Subject: RE: 3/2018/0361 Former Victoria Mill, Watt Street

Thank you for consulting the Lead Local Flood Authority (LLFA) on the above application. The LLFA is unable to provide you with a substantive response at this time for the following reasons:

### Drainage Drawings and Calculations

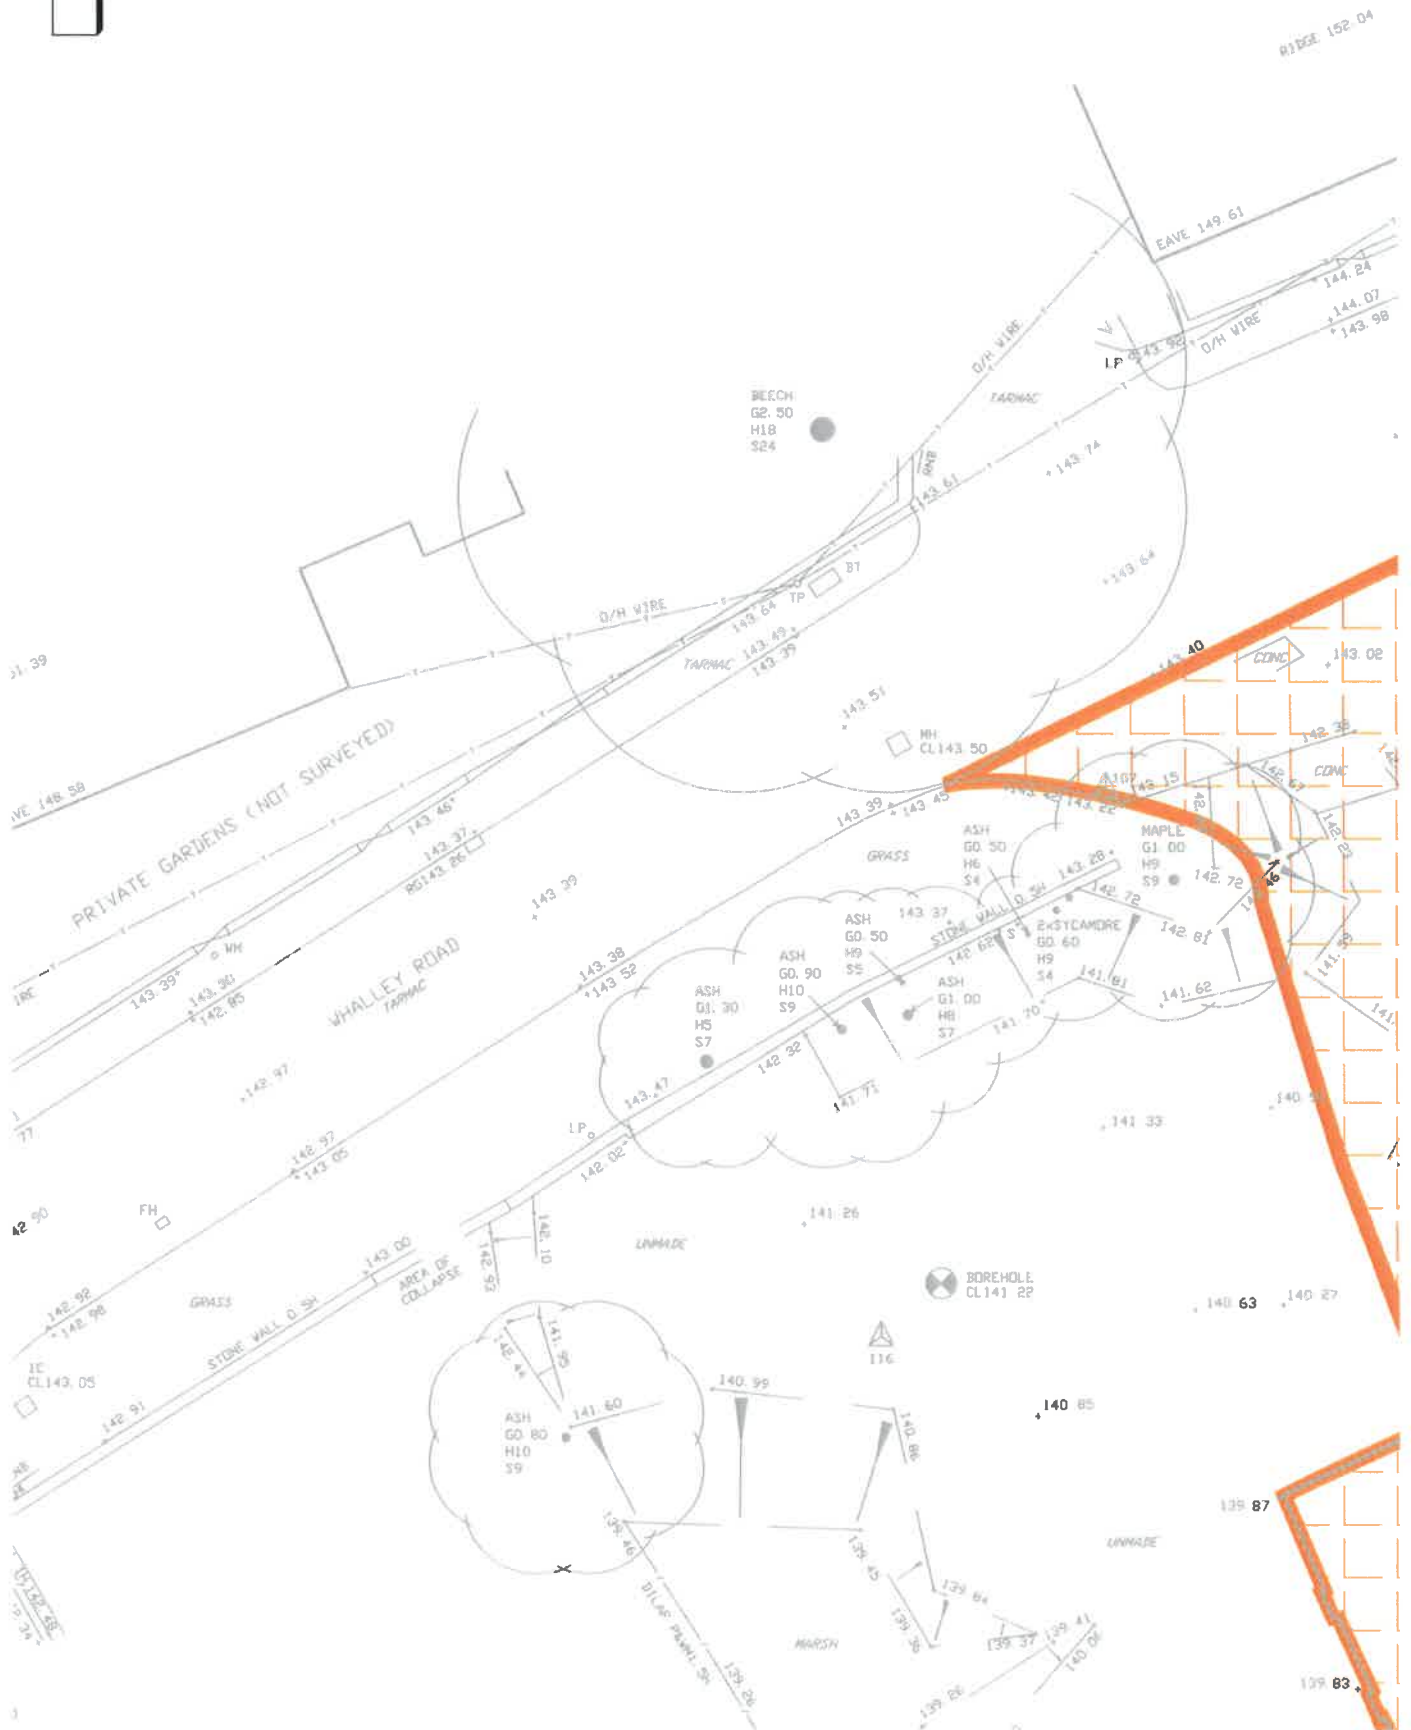
- -The LLFA is unable to complete its assessment of the development proposals because the information provided within Appendix B (topographical survey) and Appendix E (drawings and calculations) of the applicant's flood risk assessment is illegible. Please can you arrange for a legible copy of both sets of documents to be provided so that the LLFA can complete its assessment of the proposals.
